October 31, 2017

**RE: Industrial Water Engineering
Conceptual Grading and Drainage Plan
Engineer's Stamp Date 10/26/17
Hydrology File: C16D006LL**

Dana Peterson, P.E.
Senior Engineer, Planning Dept.
Development Review Services

DRAWING NAME
**GRADING &
DRAINAGE PLAN**

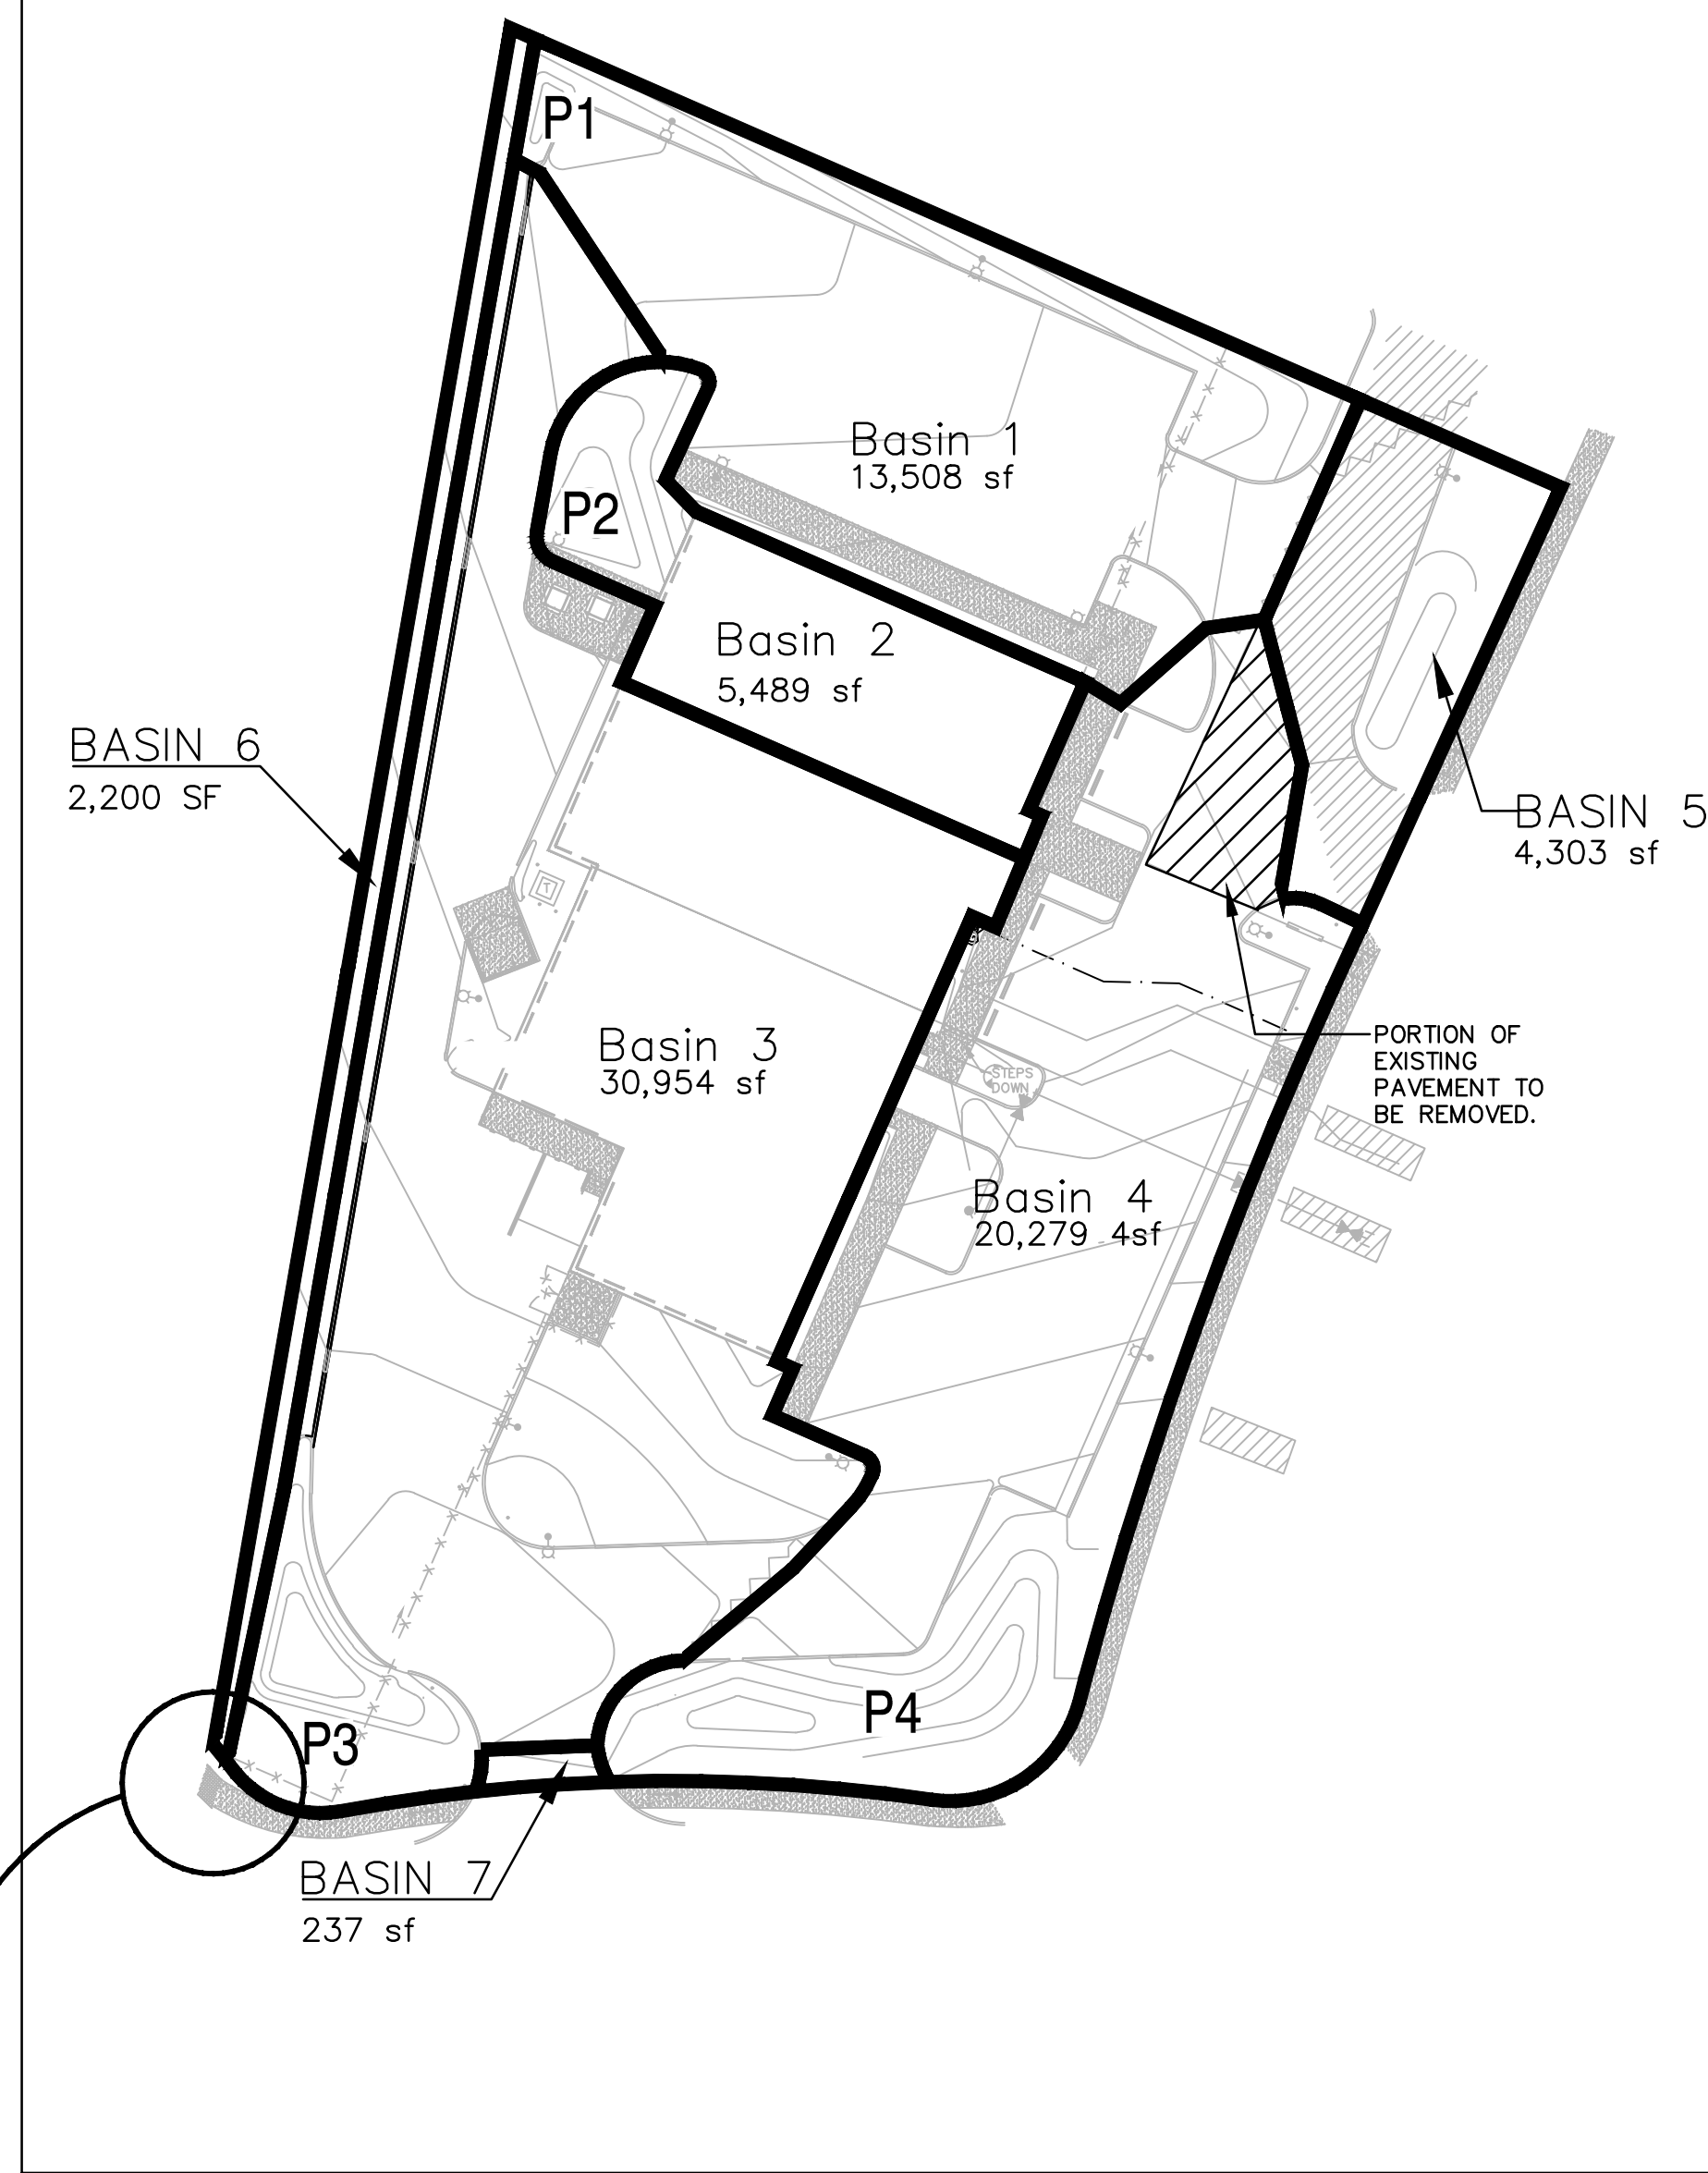
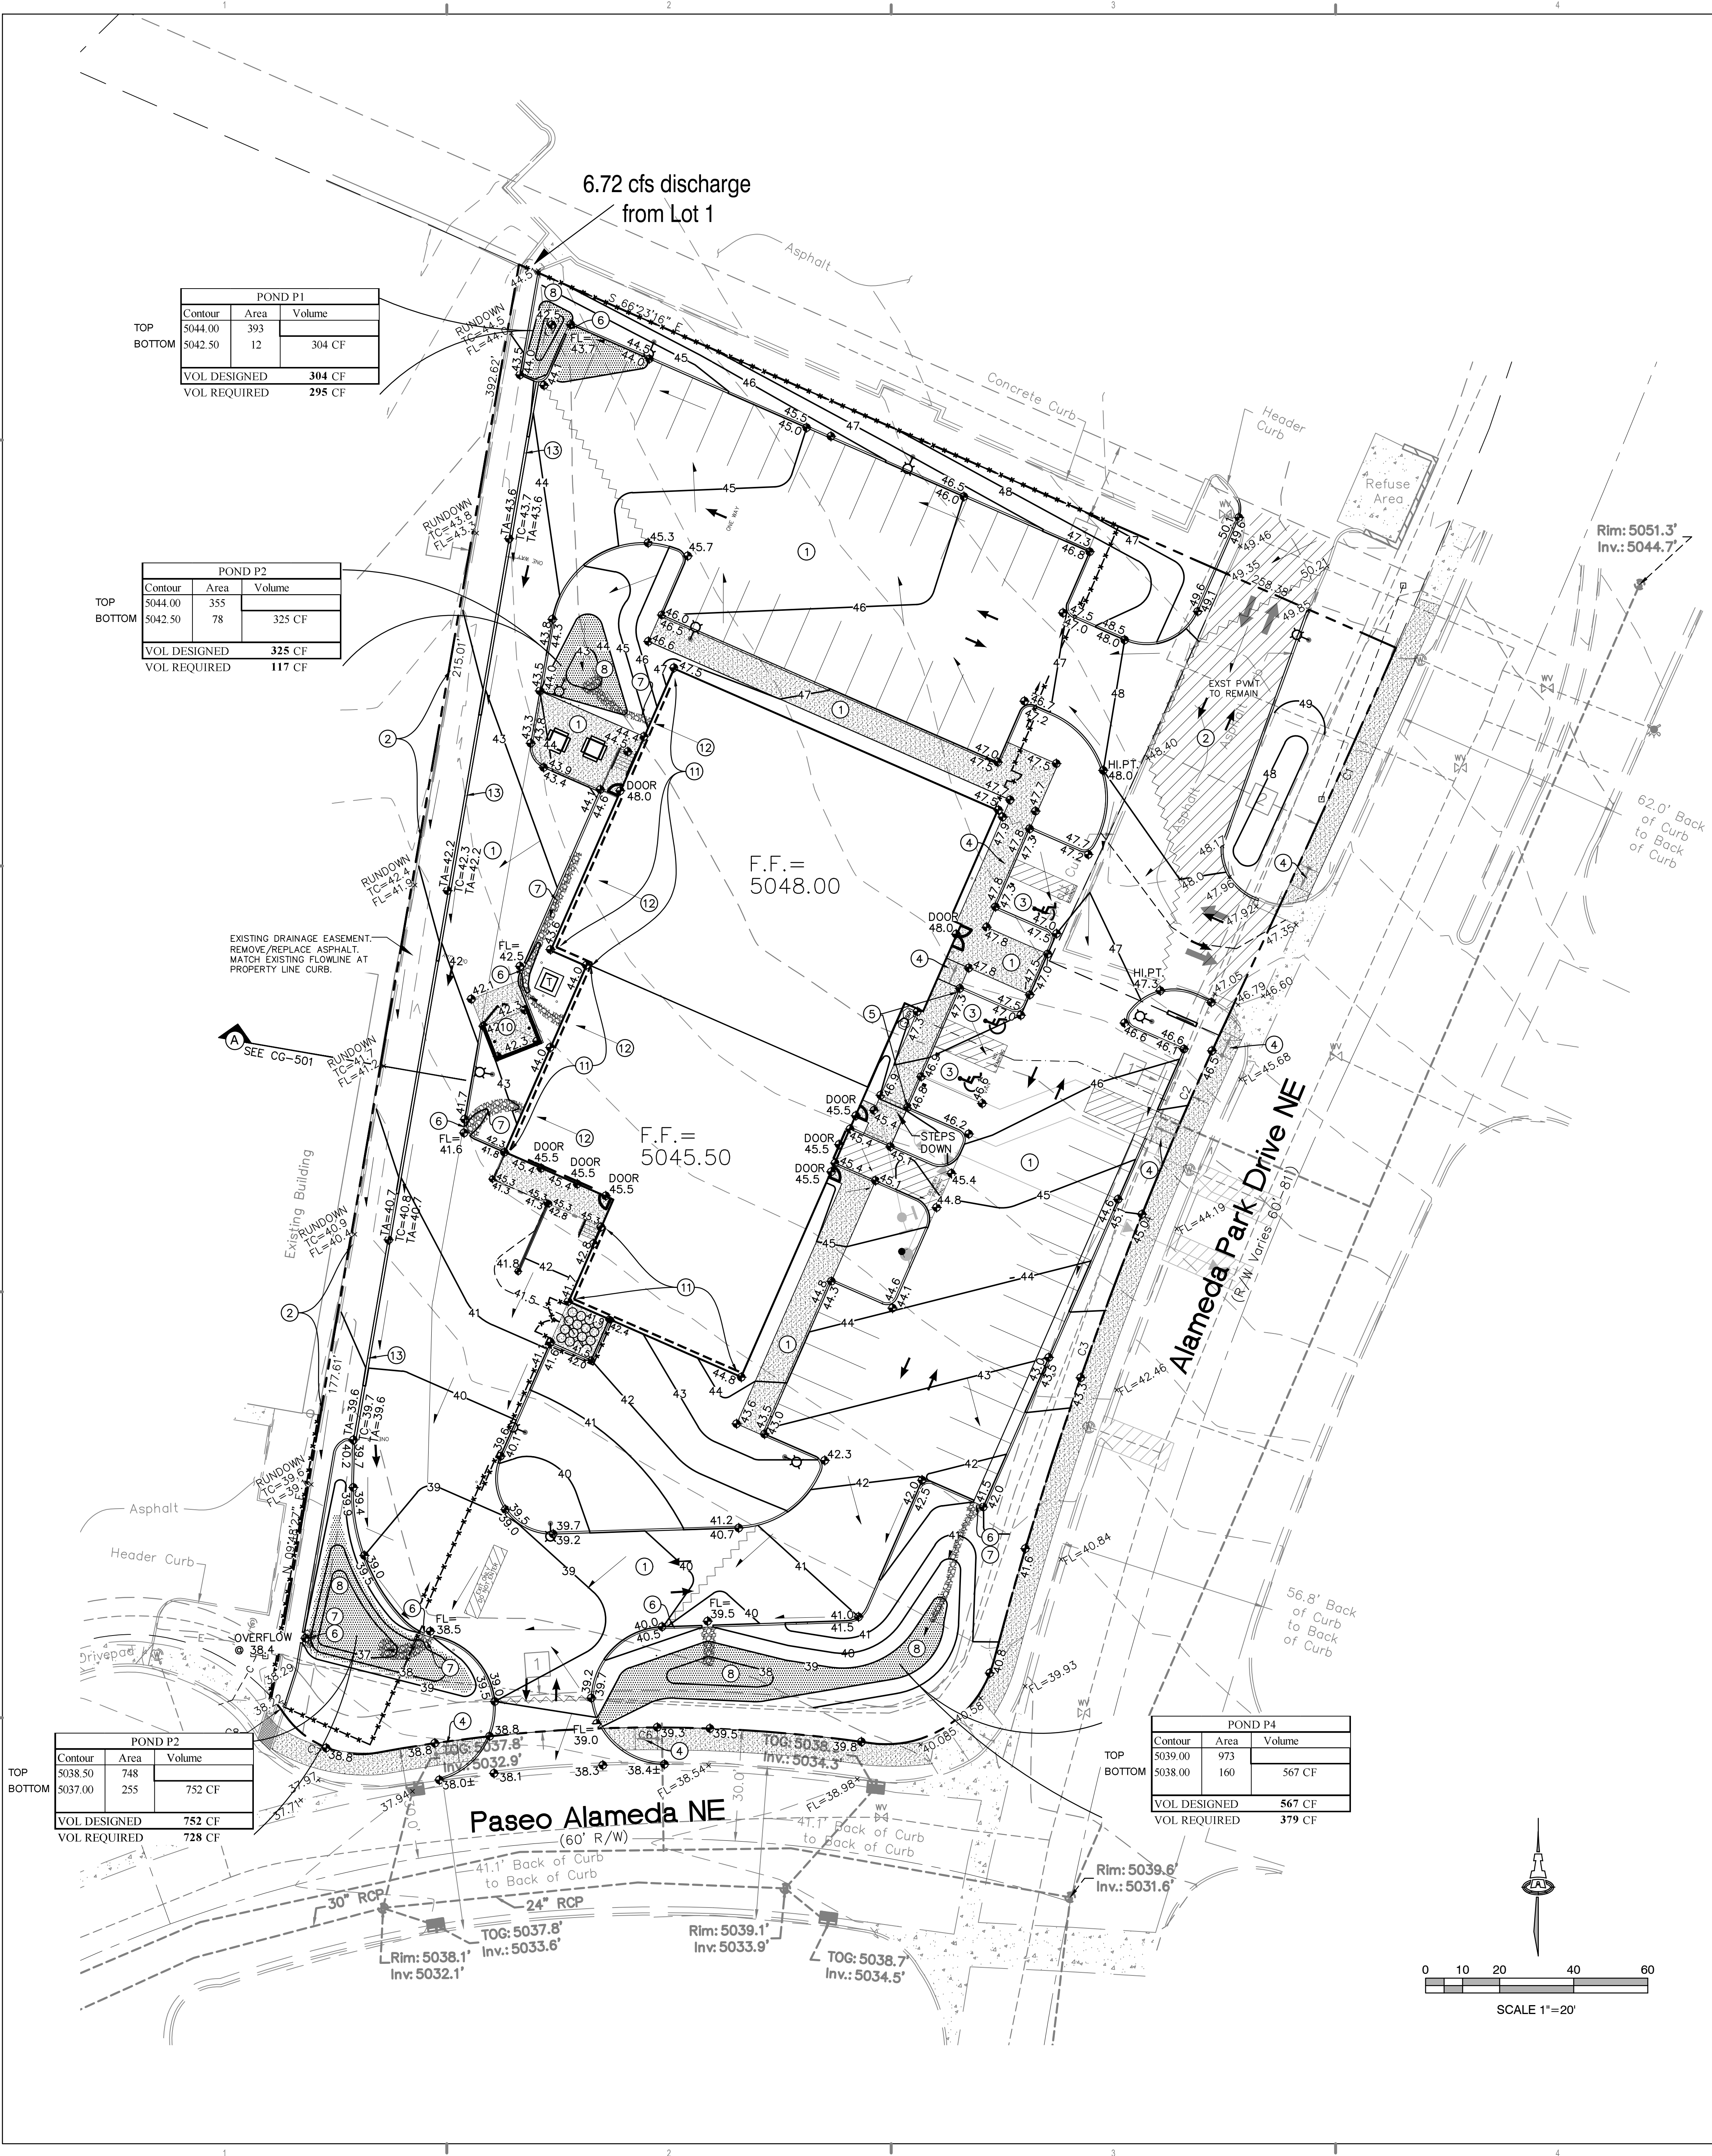
1. Correct text size on callouts to be 0.10" or larger; this applies mostly to the survey info for the water valves, drop inlets, and storm drain.
2. Call-out top of pond, bottom of pond, and volume on sheet CG-101.

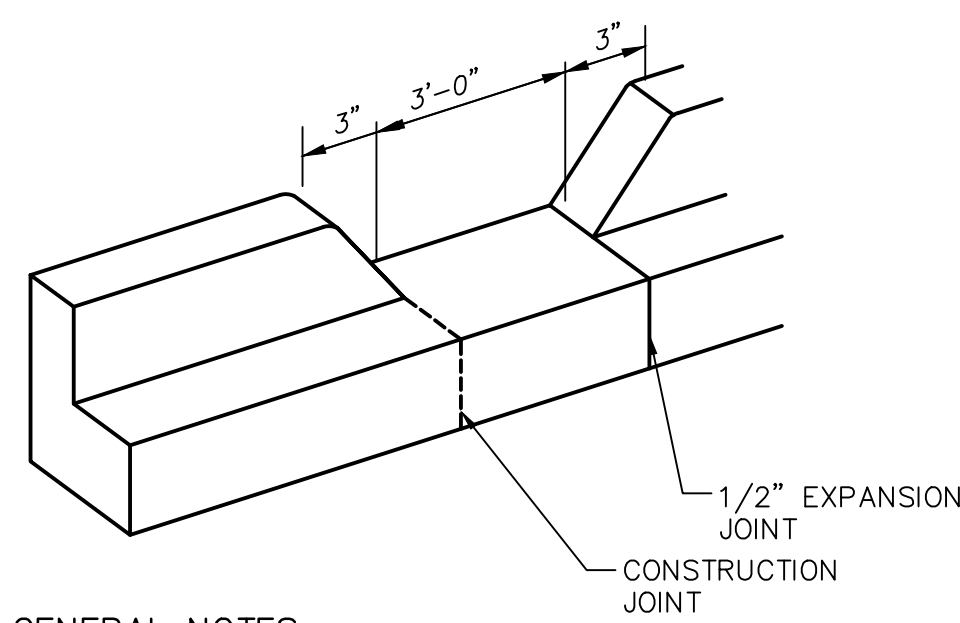
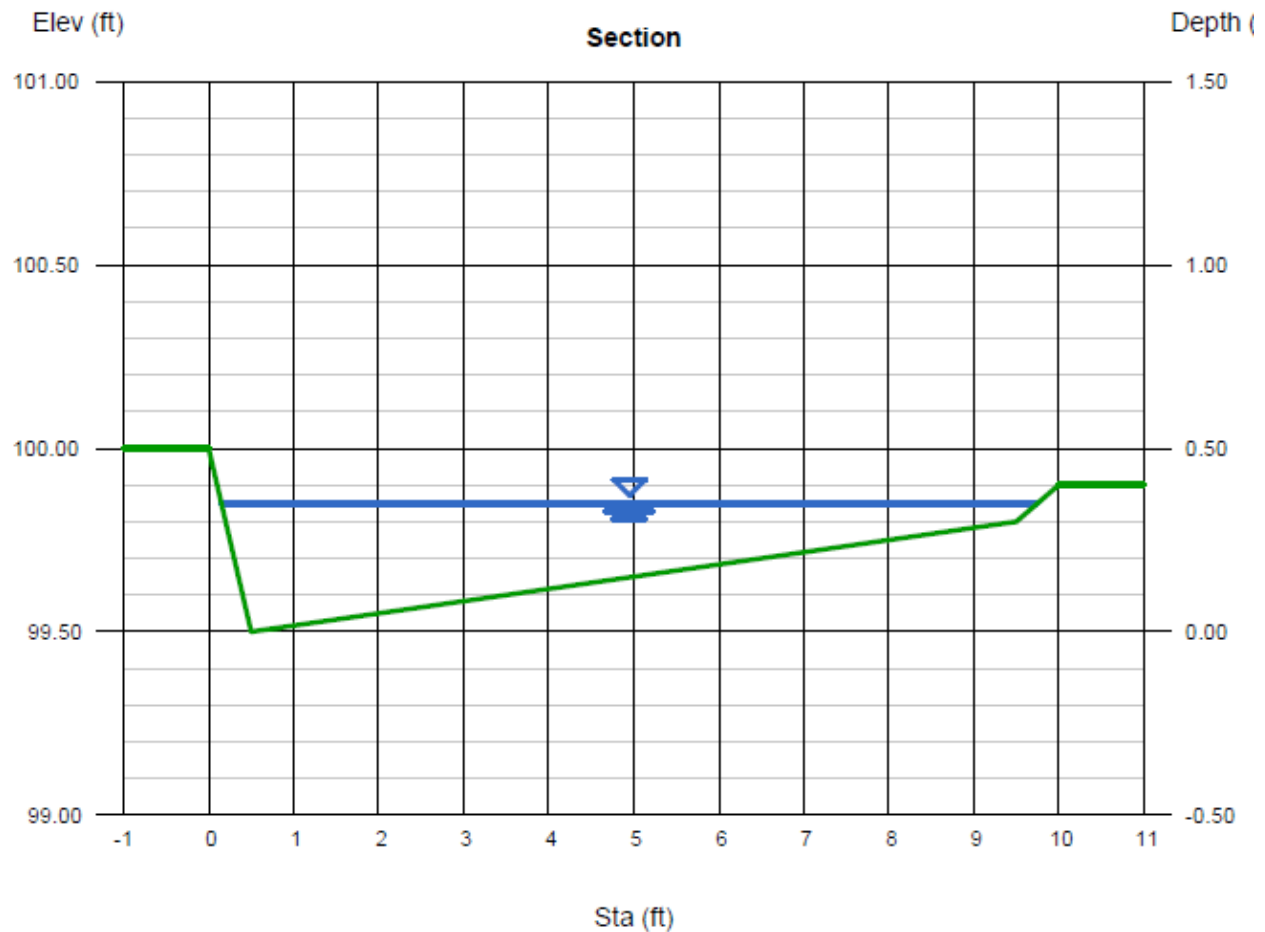
5. Provide hydraulic capacity calculations for the new sidewalk culvert and for the drainage channel downstream of the overflow from Pond P3.
